**Case Officer:** Lewis Knox

**Recommendation:** Approve

**Proposal:** Proposed first floor extension over existing garage / kitchen and a new front porch canopy

PROPOSED FRONT ELEVATION

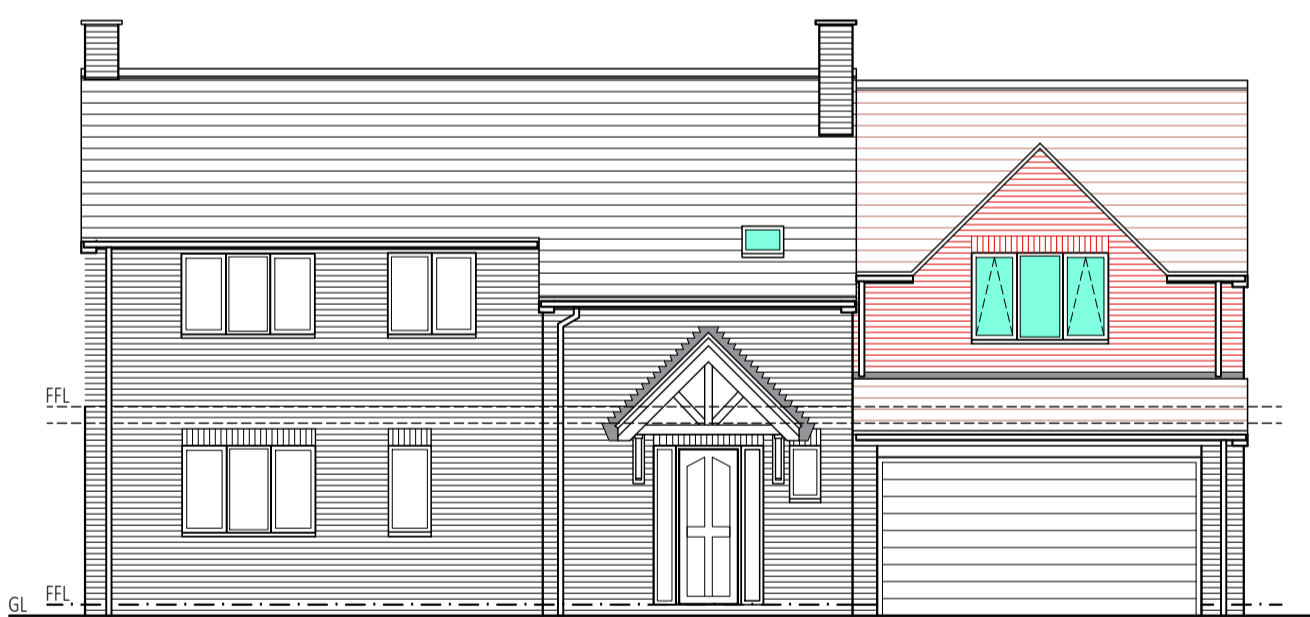
- 8.6. The proposed first floor extension would be subservient to the original dwelling with the ridge line stepped down and the front elevation set back, this is a welcome detail and allows the extension to appear secondary to the main dwelling as well as reducing any dominating impacts on the streetscene.

- 8.7. The overall design of the first floor extension would be in keeping with the application site and the surrounding neighbours. The extension would feature a small front gabled dormer which would match the gable character within the vicinity of the site, particularly the neighbouring dwelling to the south of the application site.

- 8.9. The proposed canopy porch would be a minor addition to the front of the dwelling and would not negatively impact on the character of the streetscene.

PROPOSED SIDE ELEVATION

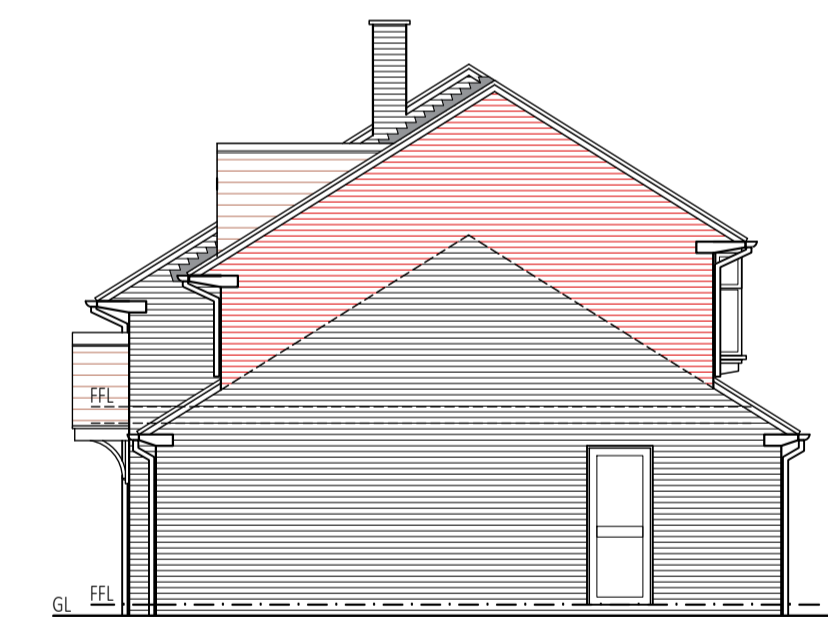
- 8.18. It is noted that the neighbours did not raise any objections to this proposal in terms of impact on residential amenity.
- 8.19. There are no windows proposed which would face west towards the neighbouring dwelling and would not impact on privacy in this respect.

PROPOSED FIRST FLOOR PLAN

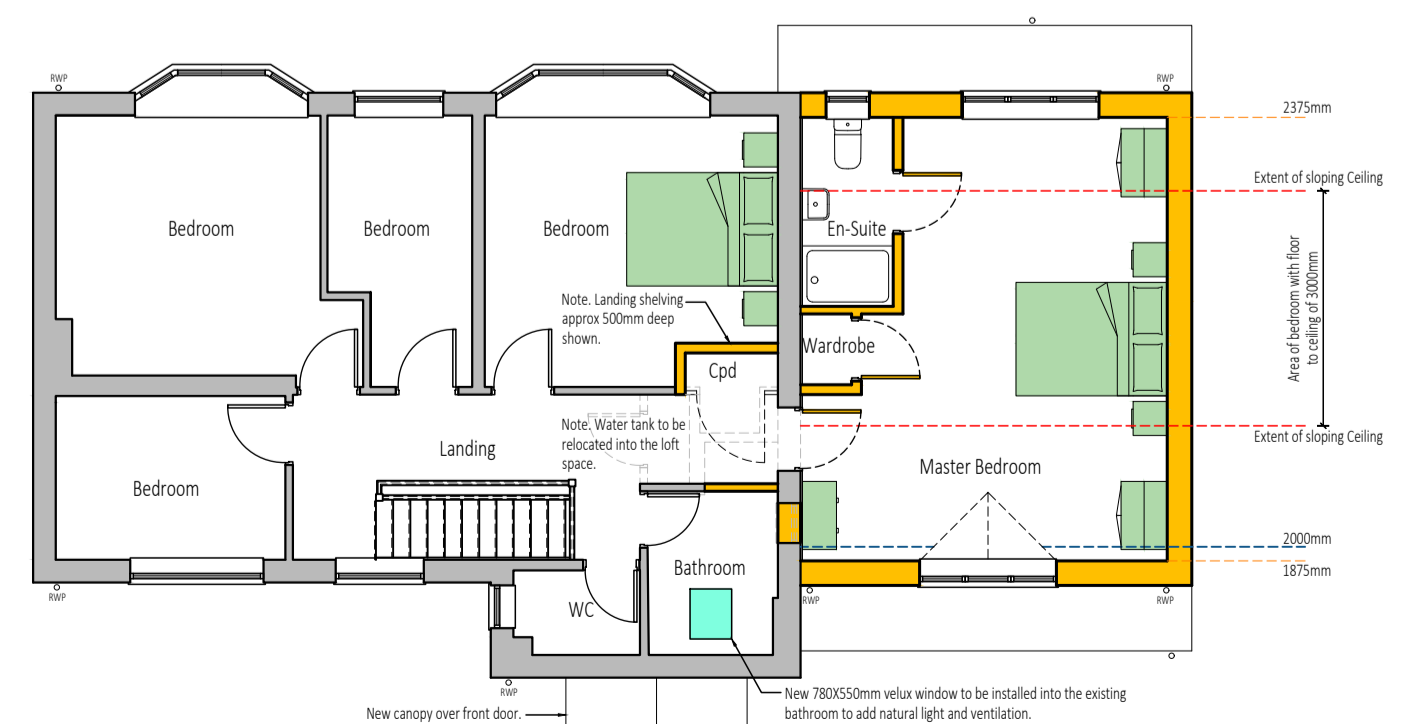
- 8.13. The proposed first floor extension would run close to the boundary with the neighbouring property to the west and given that the application property is set back from the neighbouring dwelling to the west there would be some impact on the residential amenity of the closest first floor window to this dwelling.

- 8.14. The extension would have roughly the same width as the existing dwelling and so would not protrude further than the existing rear elevation at the site but would be significantly closer to the neighbouring dwelling to this side. The extension would extend approximately 3.0m beyond the rear of the neighbouring dwelling and so will have some impact.
